Arun District Council
Arun Civic Centre
Maltravers Road
Littlehampton
West Sussex BN17 5LF
Planning & Building Control General Enquiries
Tel: (01903) 737756 Fax: (01903) 730442
Dx: 57406 Littlehampton
Minicom: 01903 732765
e-mail: planning@arun.gov.uk
website: www.arun.gov.uk/planning

Application No: LU/241/20/CLE
Site Address: 6 Selborne Place Selborne Road Littlehampton BN17 5NH
Description of works: Lawful development certificate for existing use of building as a large House in Multiple Occupation (Sui Generis).

Thank you for your internet representation made on 25th October 2020 which has been recorded as an objection with the comments as follows:

Proposed Ground Floor Plan 1:50

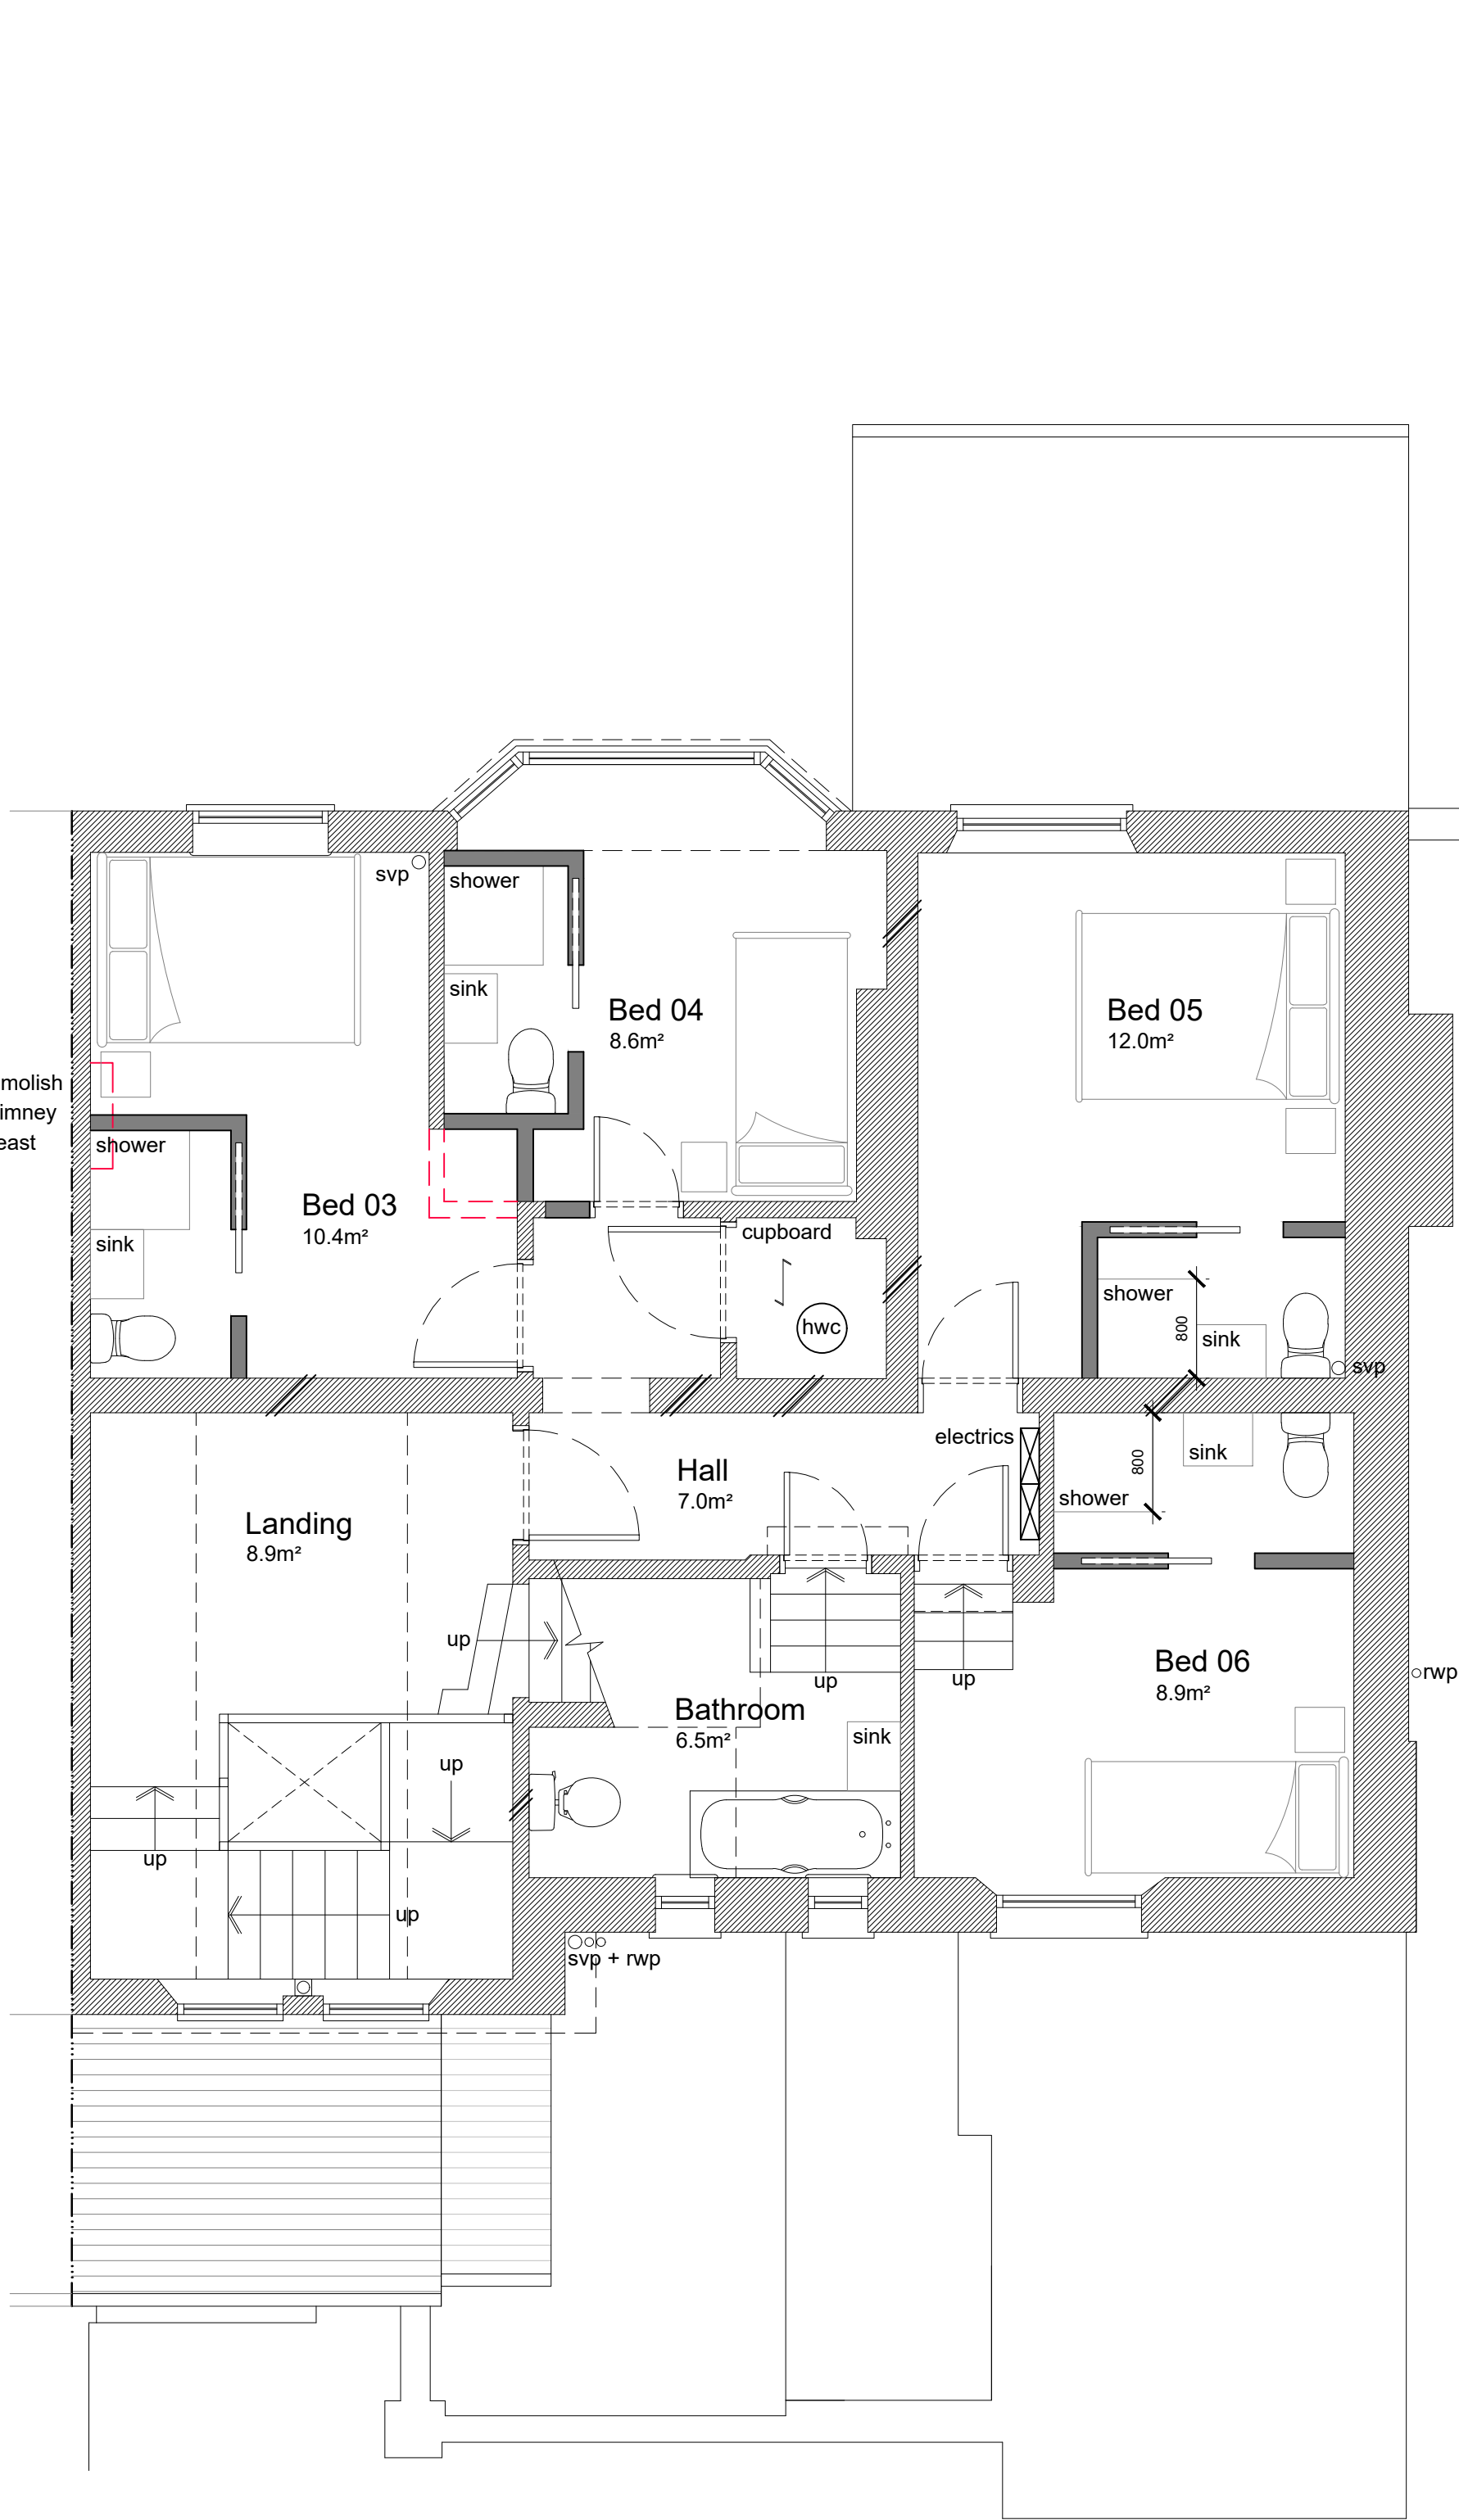
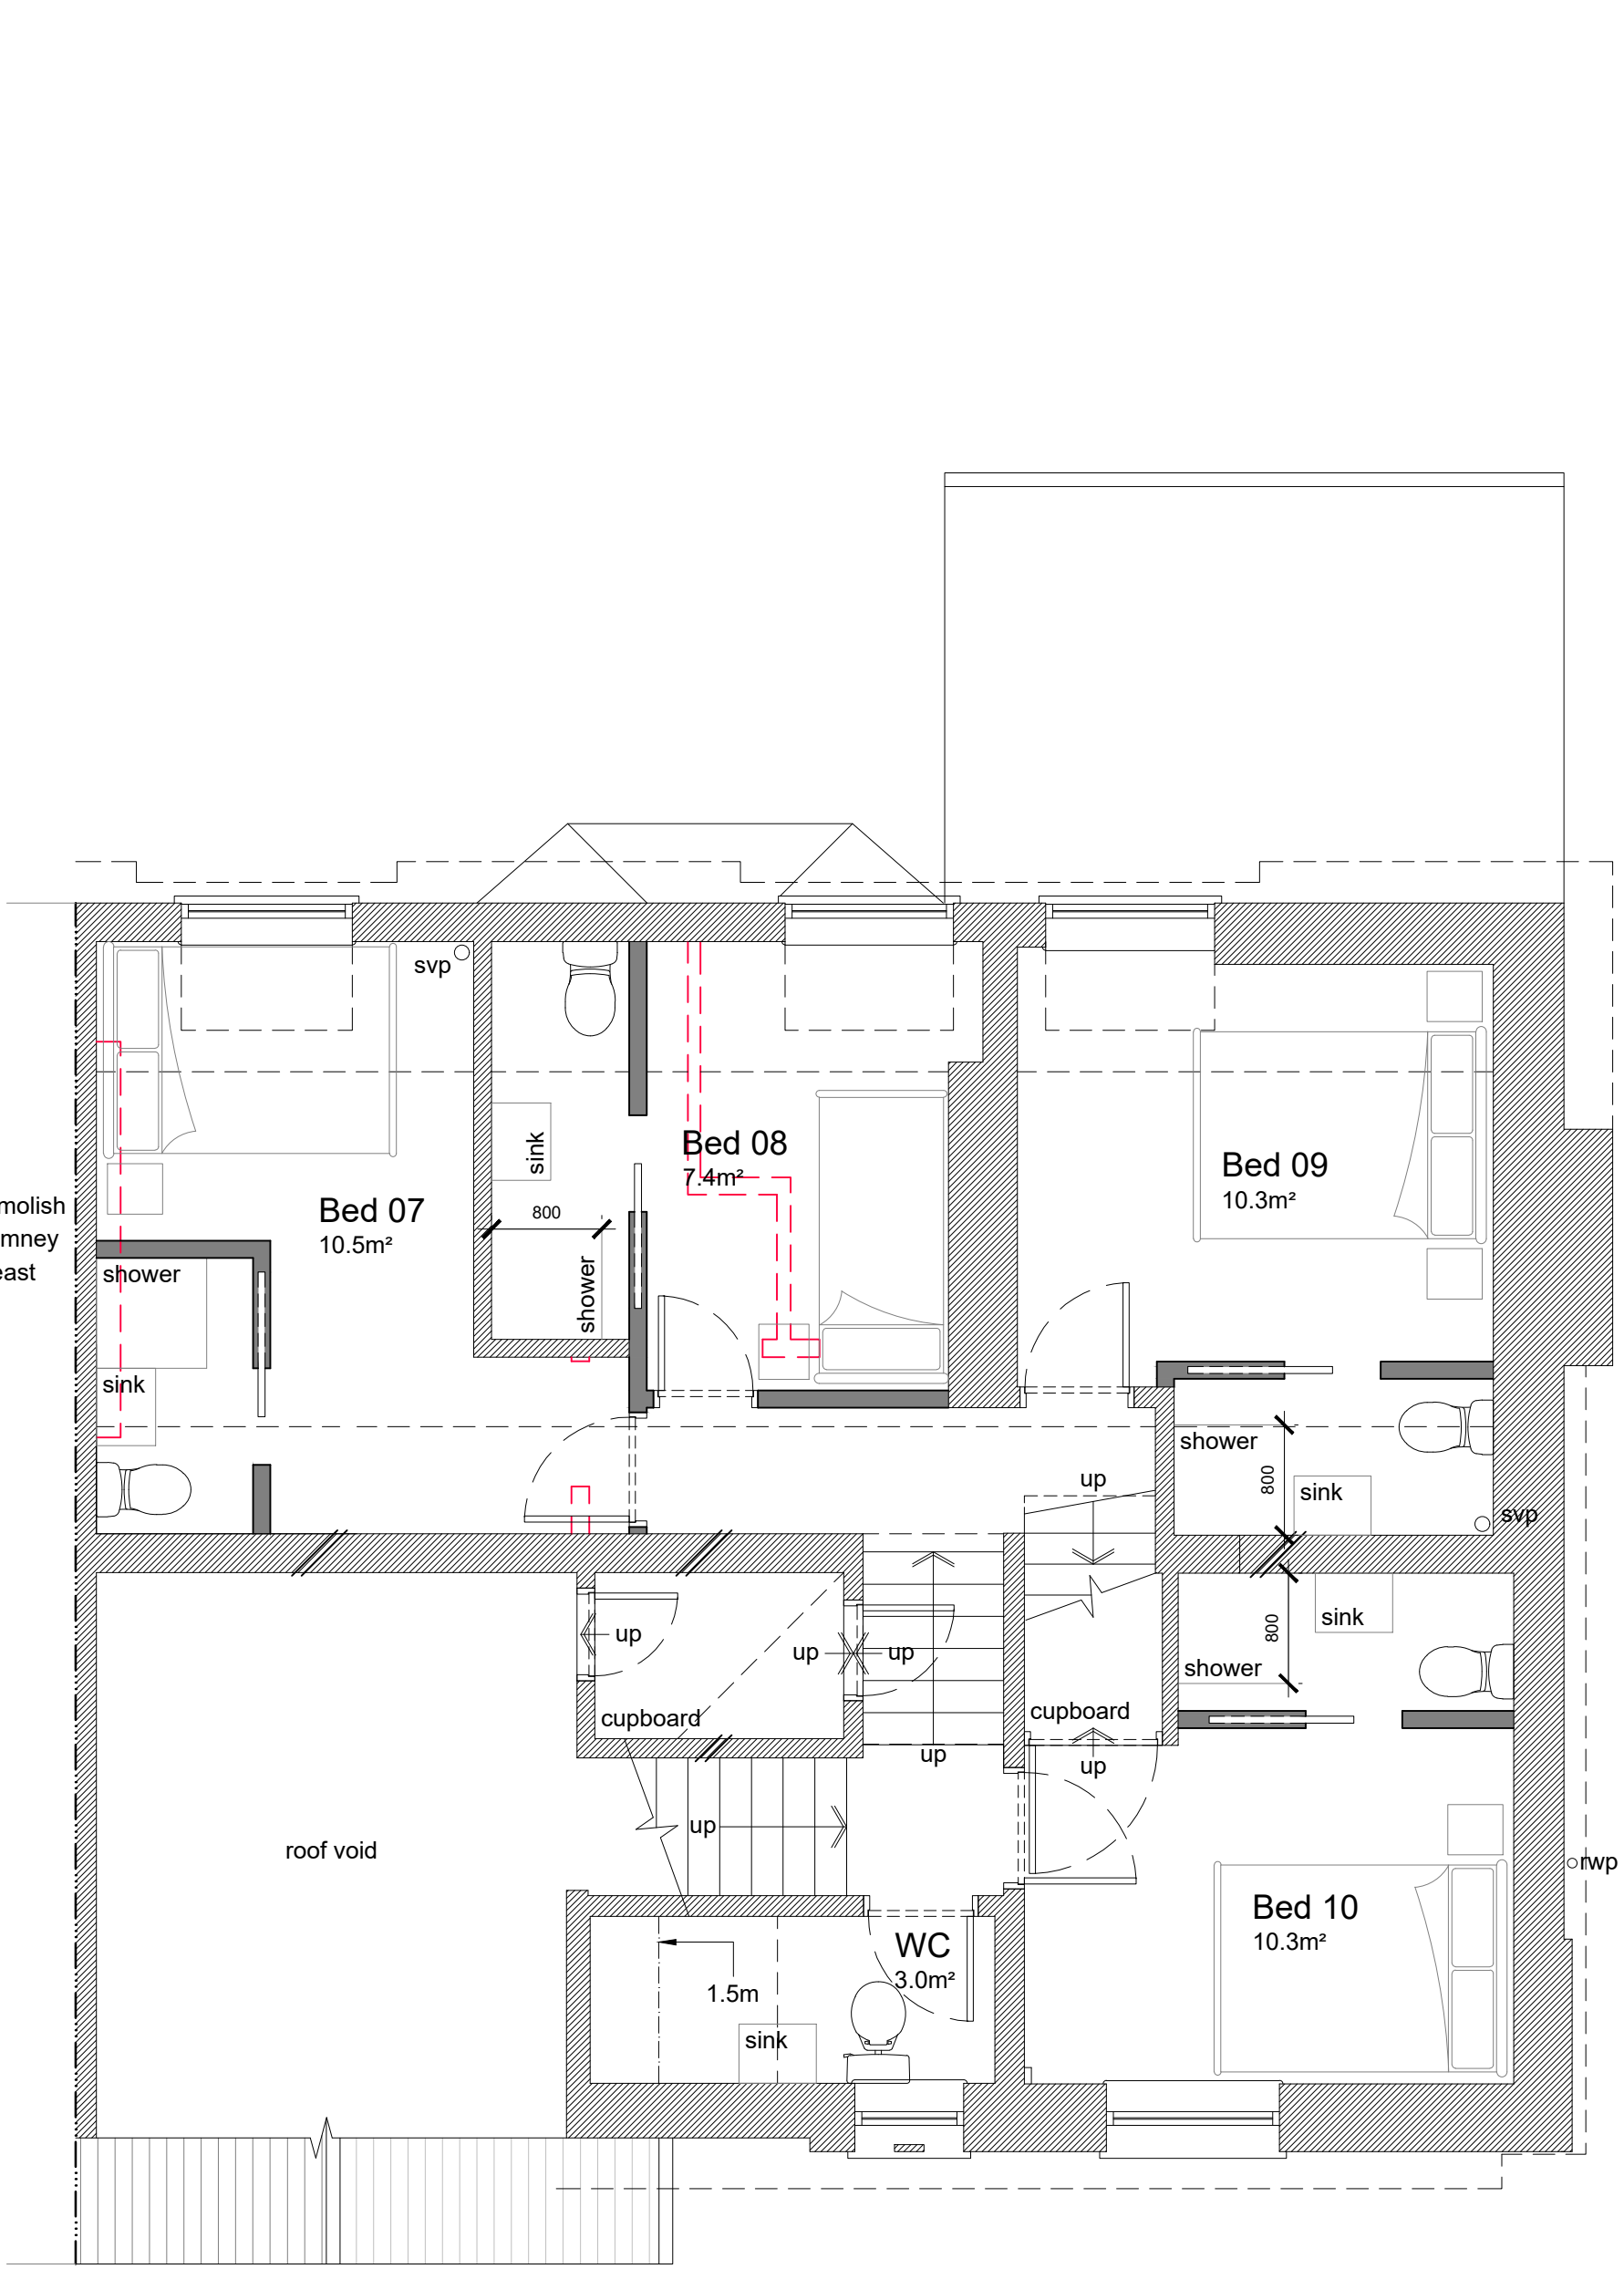
1: We believe the plans, which increase the rooms from 8 - 11, represent an overdevelopment of this site. The plans show 6 double beds and 5 single beds suggesting an occupation of 17 people. In this time of a pandemic this is irrational - the communal dining area is only 16 m² (less than the mandatory 20,5 m² ADC HMO Standards) The conservatory (referred to communal lounge) is unlikely to meet the current Building regulations (See pg 25, Standards for Houses in Multiple Occupation, Arun District Council)

5: From what we can see there are not enough sinks in the kitchen for the number of proposed residents (local standards for HMO state 1 per 4 occupiers or part thereof.) From our reckoning, a minimum of 3 and possibly 5 are required, we only see 1-2.

6: In fact the kitchen/scullery seems have a staircase in the centre of it, with very little worktop space for the number of people who will be expected to cook for themselves in it. ADC HMO standards dictate 0,5 m per user which with a potential 17 users suggests 8,5 m of worktops and at least 5,5 m if rooms only are taken into account.
